RESPONSE TO REQUESTS FOR INFORMATION (RFI)

**Proposed Waste Management facility (SSD-62855708)
2-4 Hale Street, Botany**

Reference: 23.464r07v05
Date: September 2025

Project No.	Drawing Phase	Drawing No.	Rev.
23.464	RFI	TX.06	A

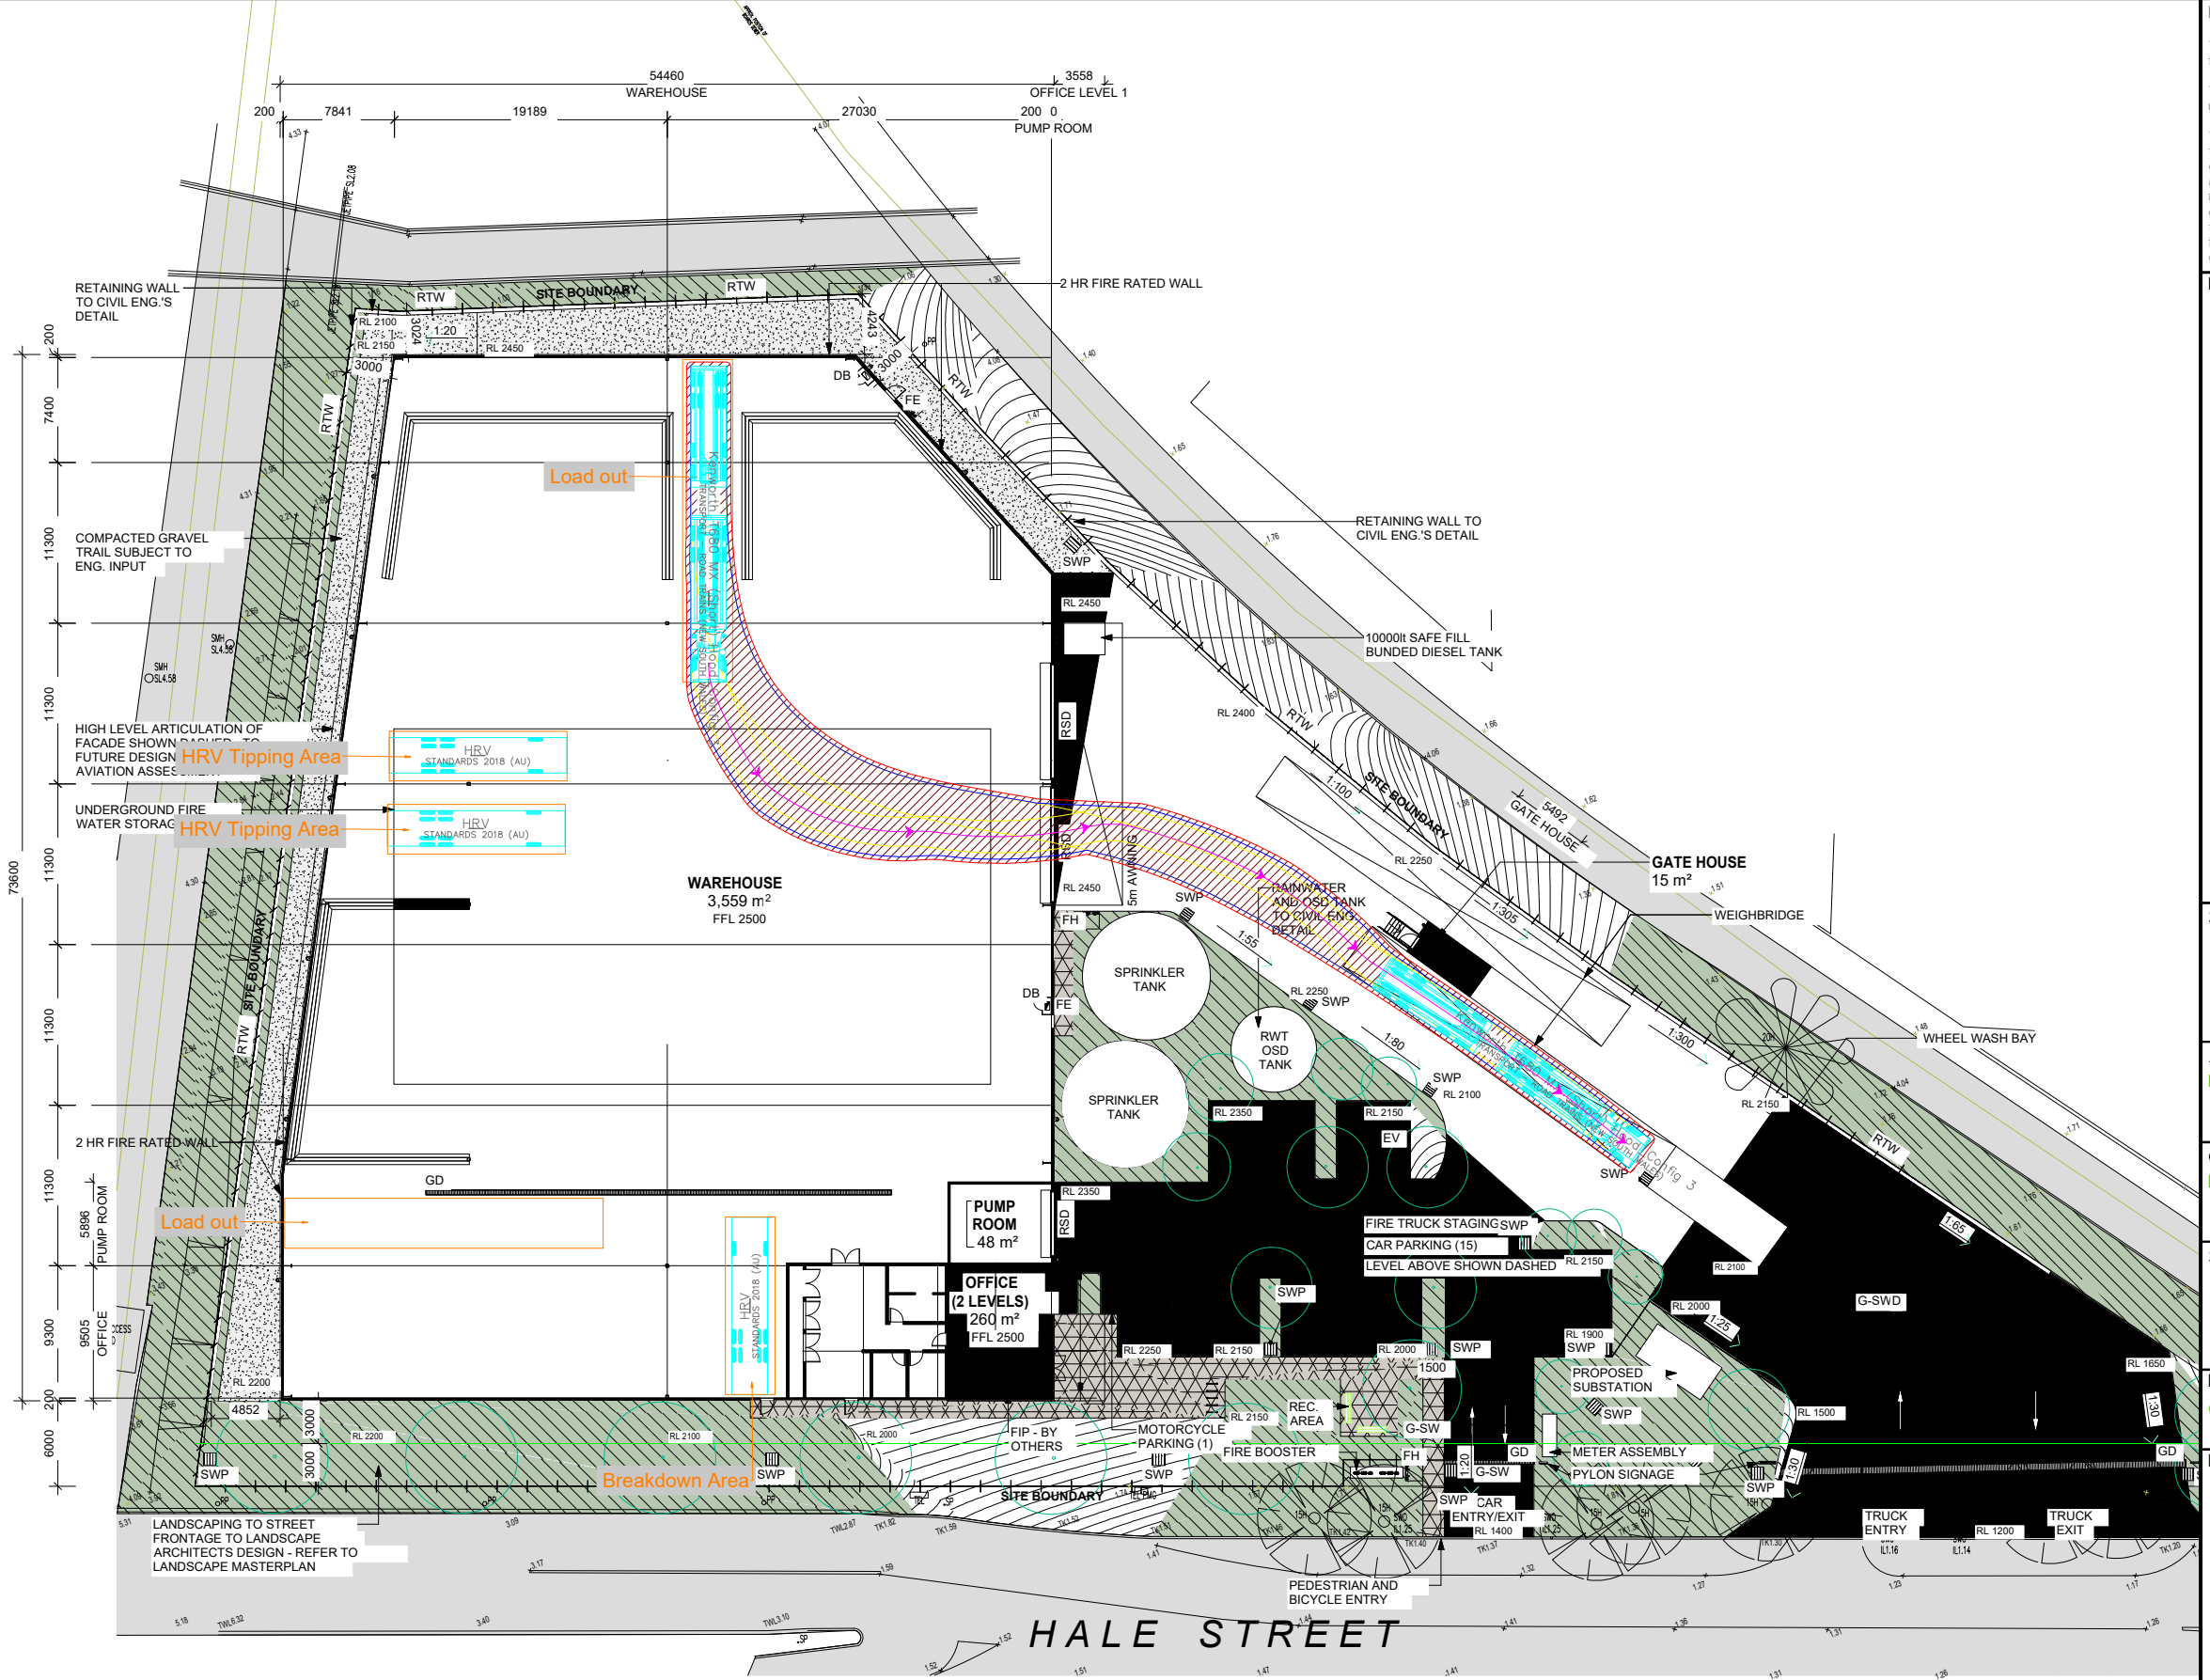
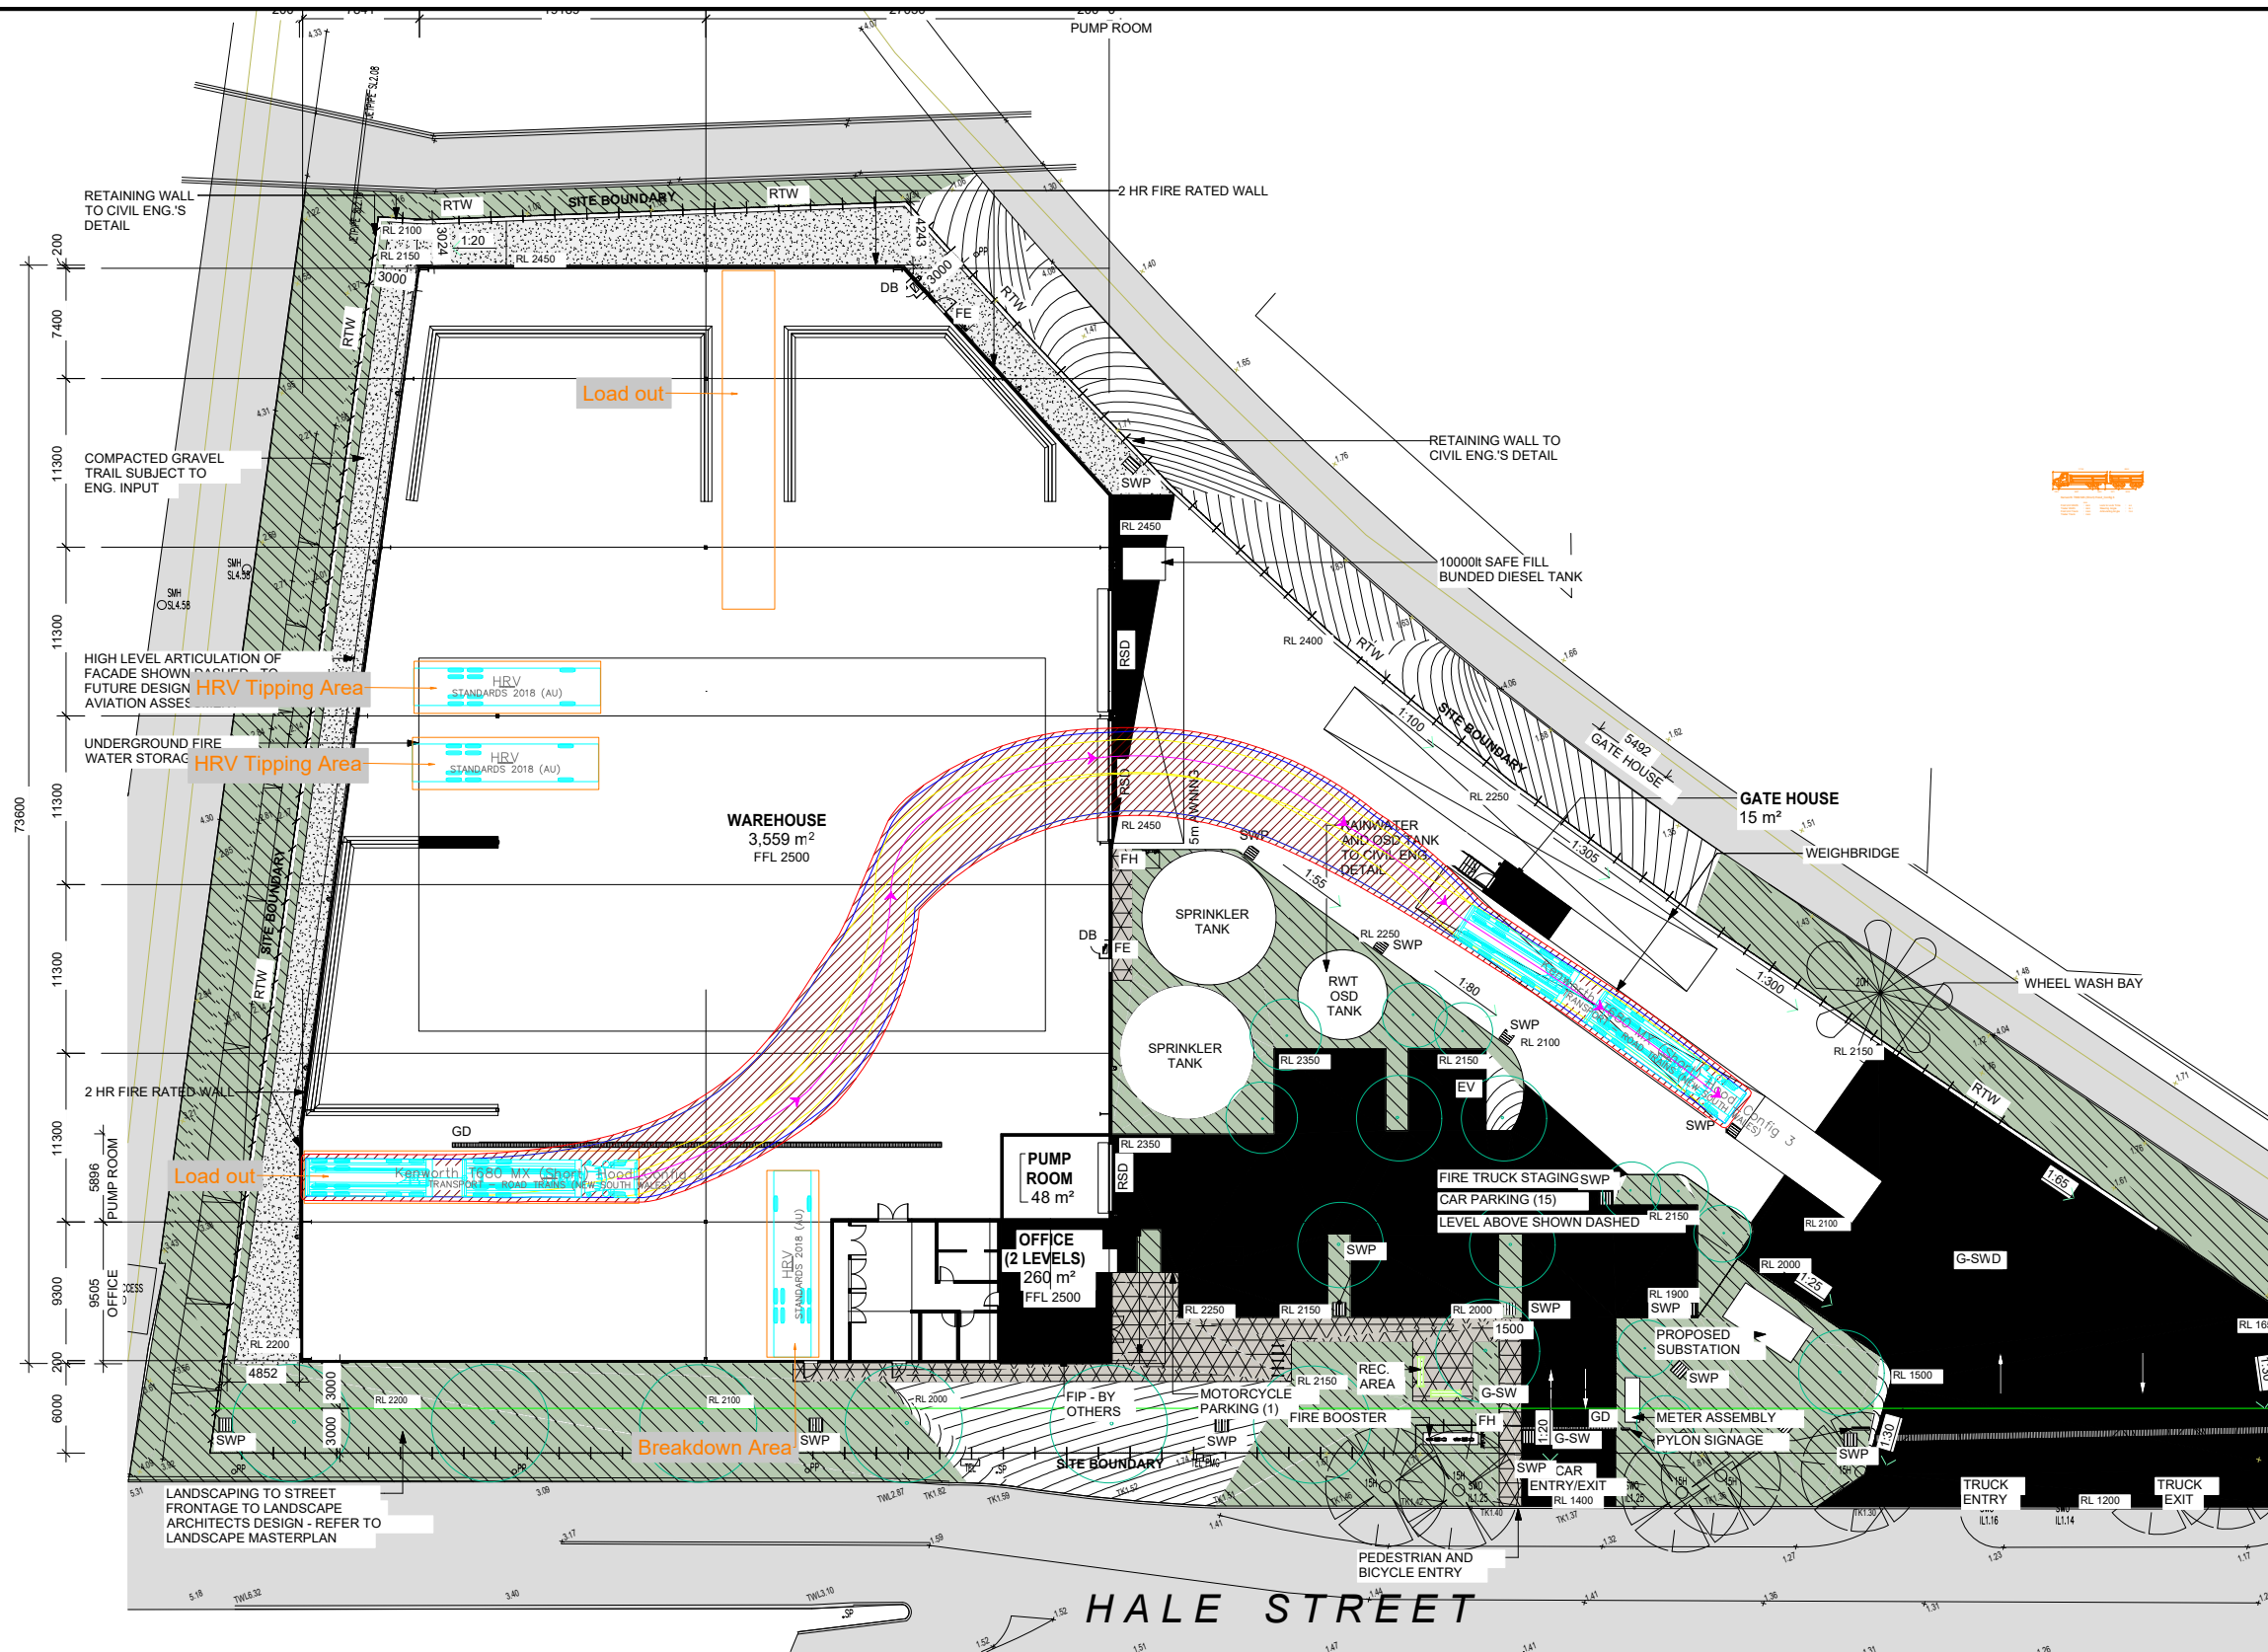
The swept path analysis shows the movement of a B-double exiting the site on a separate drawing to the swept path of a B-double accessing the site. It is not possible to determine if there will be any conflicts if these two movements occur simultaneously. Please provide a plan that shows a B- double entering and exiting the site simultaneously demonstrating that this movement can occur safely and without any conflict to either vehicle or on-street parking, and without crossing the centreline of Hale Street.

- *“Details of how trucks collecting waste will not conflict with incoming vehicles unloading waste – to be supported by commentary and figures clearly demonstrating how this will be achieved.”*

Having considered the above, **Figure 1** below clearly demonstrates a 26m B-double vehicle will be able to satisfactorily enter the site whilst another 26m B-double vehicle is waiting to exit the site, under conservative operational assumptions.

Reference should be made to the swept path analysis provided in **Attachment 3** showing the satisfactory truck movements to / from the proposed breakdown bay. Implementation of measures as part of an operational traffic management plan is an enforcement matter is to be addressed by the operator.
